Your Ref: OWPC6408
Our Ref: AW/182/15/HH 19-06-2015
Please ask for:
Richard Temple

Town & Country Planning Act 1990 (as amended)
Town & country Planning (Development Management Procedure) (England) Order 2015

Conversion of existing garage & extension to create annexe accommodation
14 Bradlond Close Aldwick

Plan. [As Proposed.]

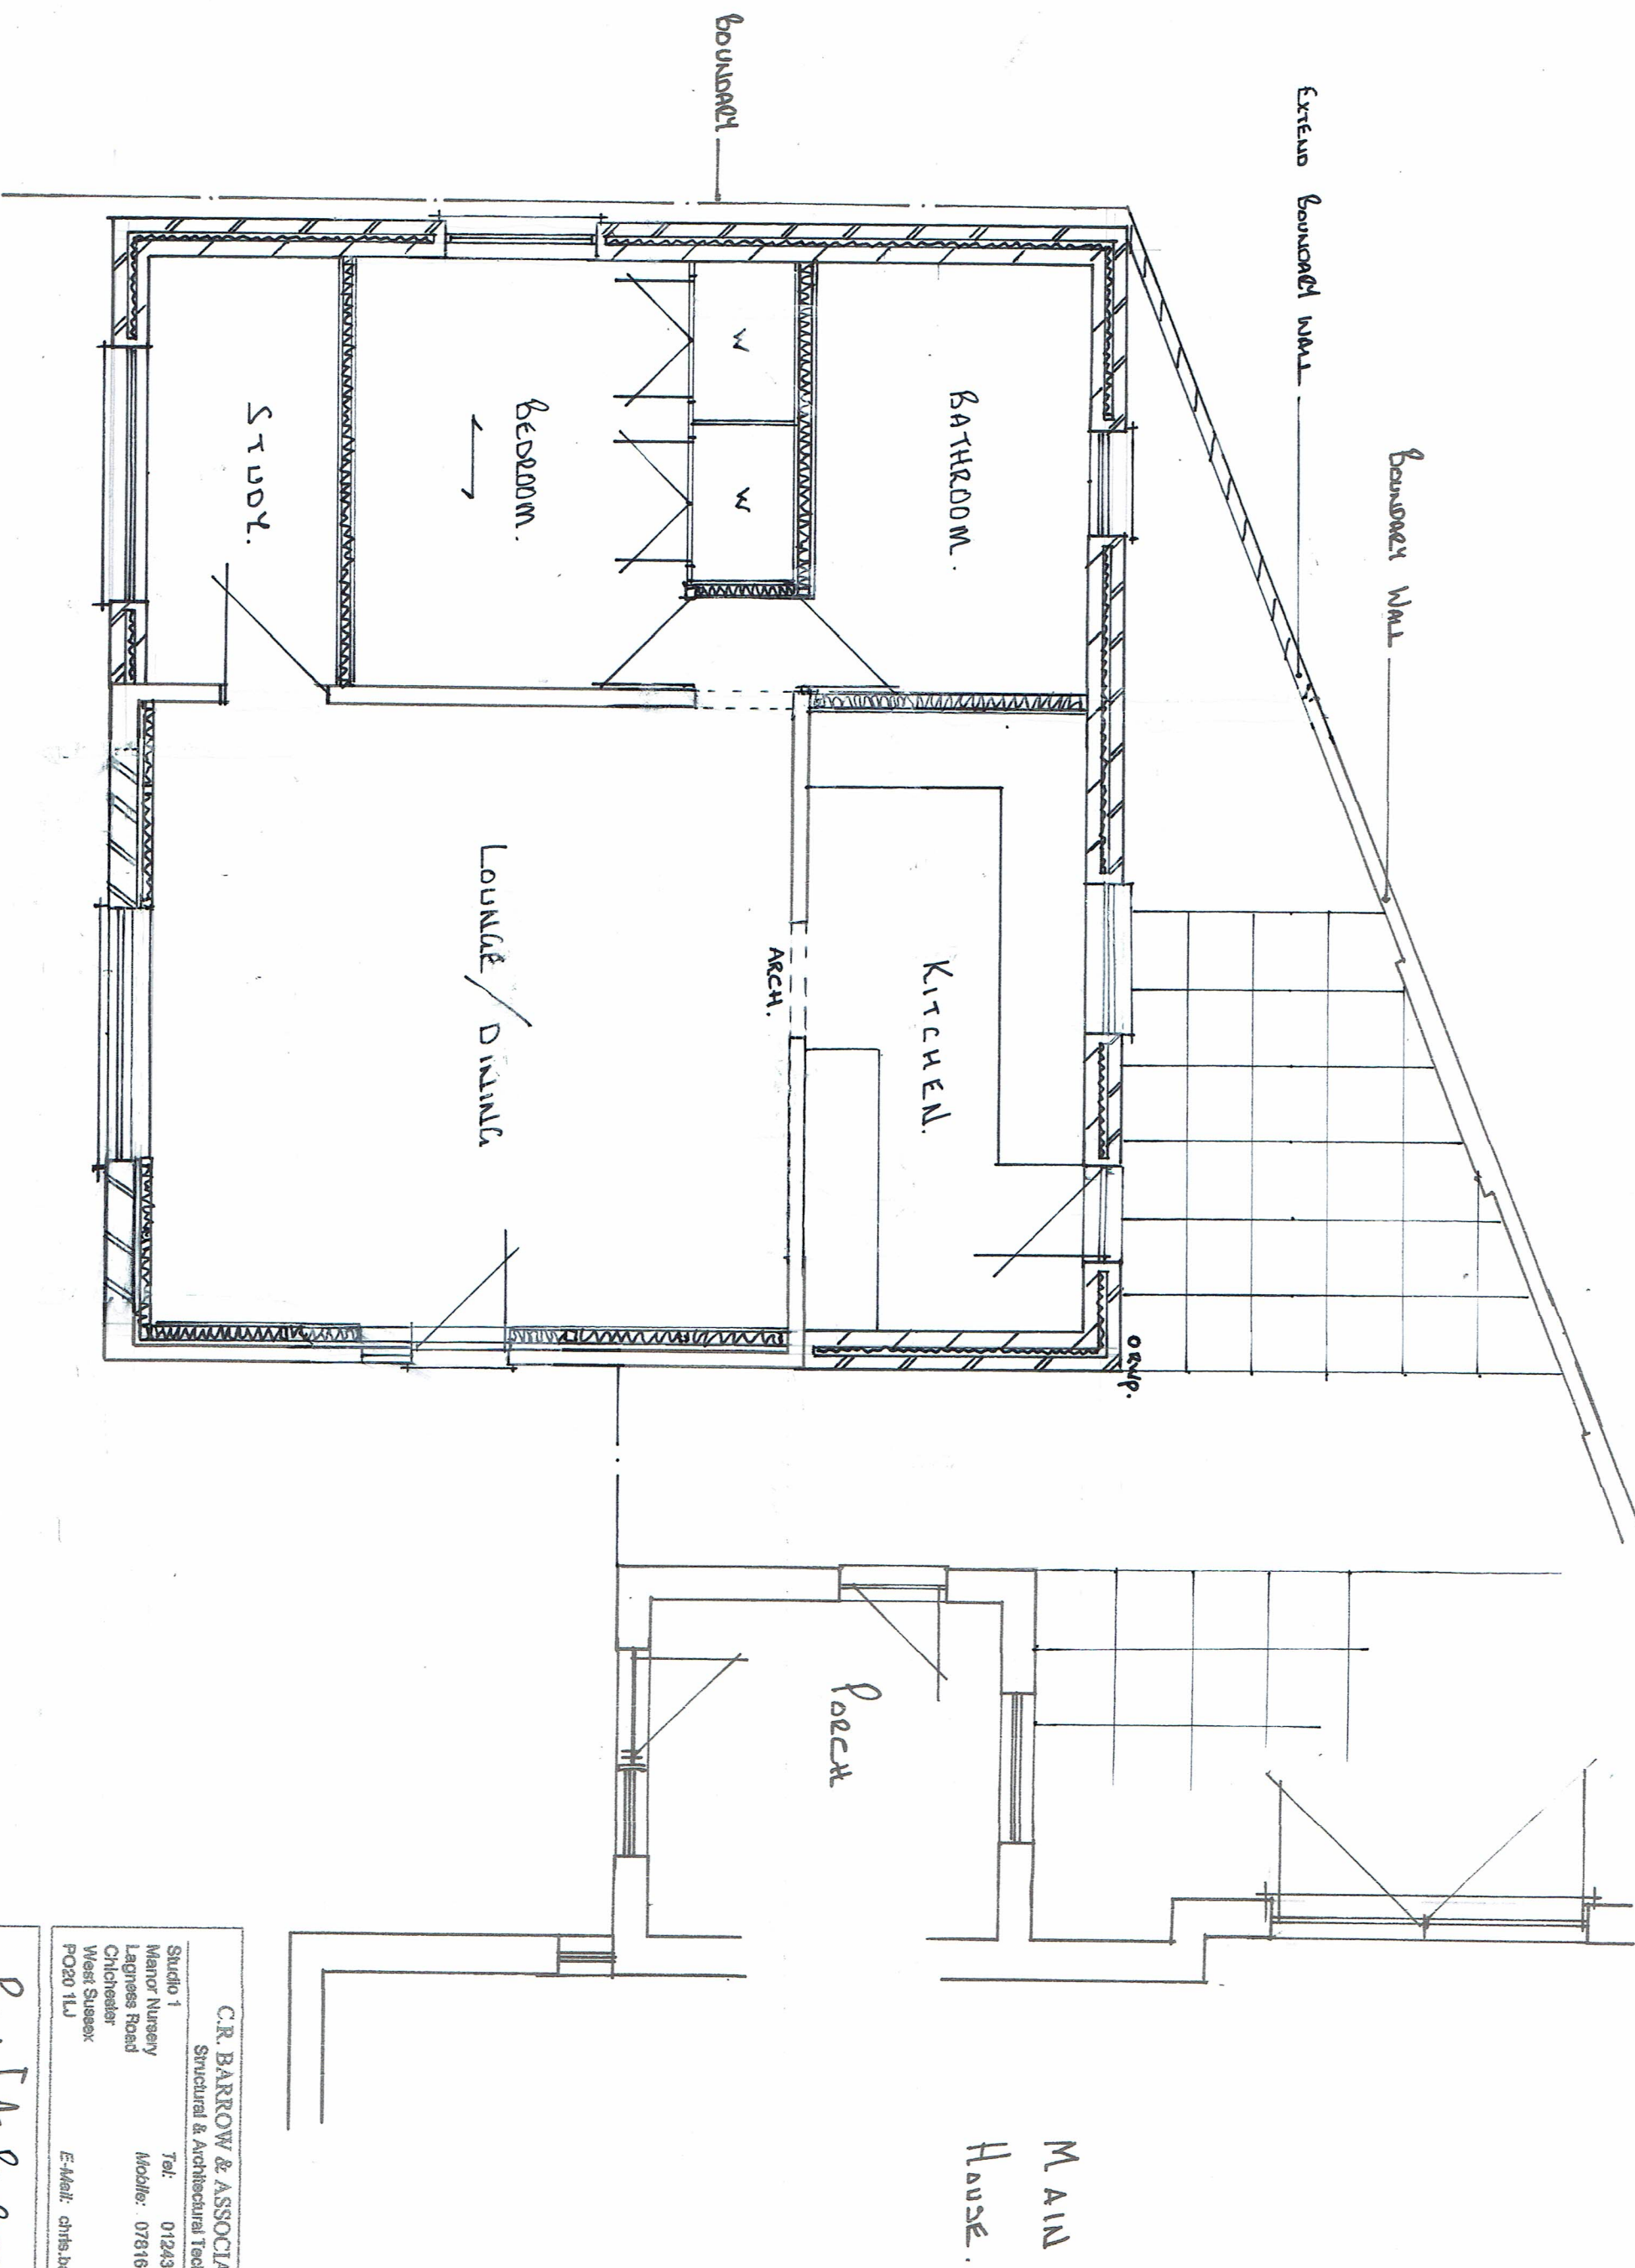
- 1 The proposed development has no attachment to the existing construction and constitutes a completely separate detached 1 bedroom dwelling. As such it is not in keeping with other properties in this section of the estate.*

ELEVATIONS. [As Proposed]			
Scale	1:100	Drawn By	C.R.B.
Date	APR 15/17	Checked	
Drawing Number	1203 - 05

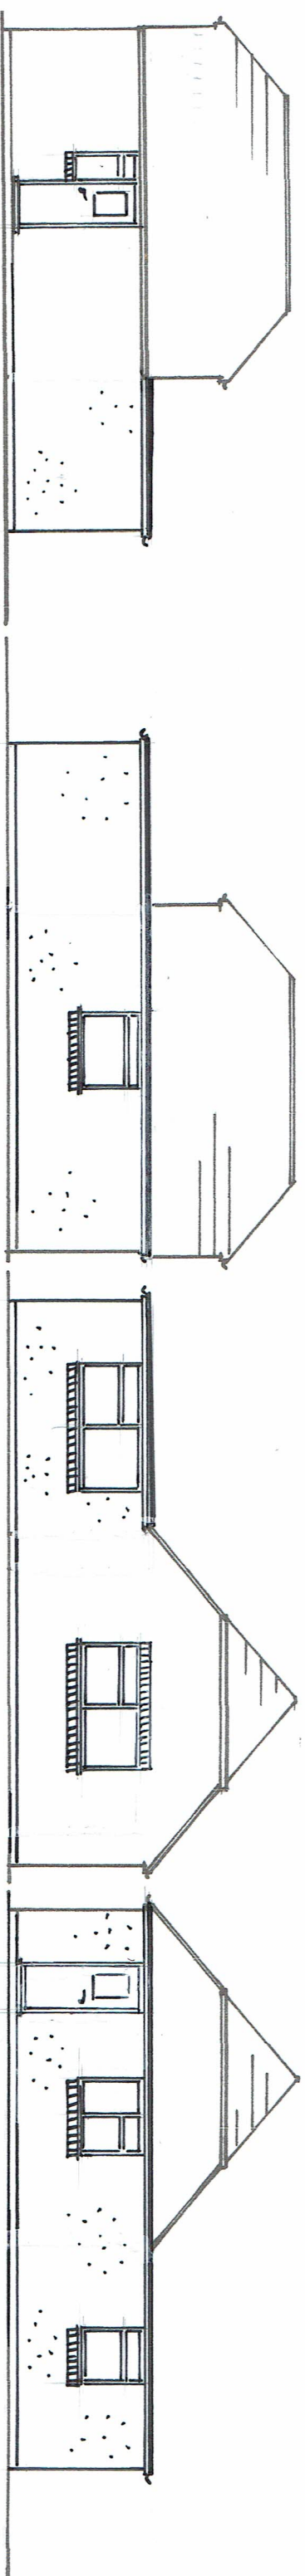
- 2. The proposed flat roofed extension is not in keeping with other properties in the vicinity which were carefully designed to be of character with tiled pitched roofs.*

- 3. The proposed development is forward of the existing building line and will adversely impact the visual aesthetics of the street.*
- 4. The loss of garaging is likely to result in on street parking. As the site is on a corner of the street this on street parking will affect nearby properties.*
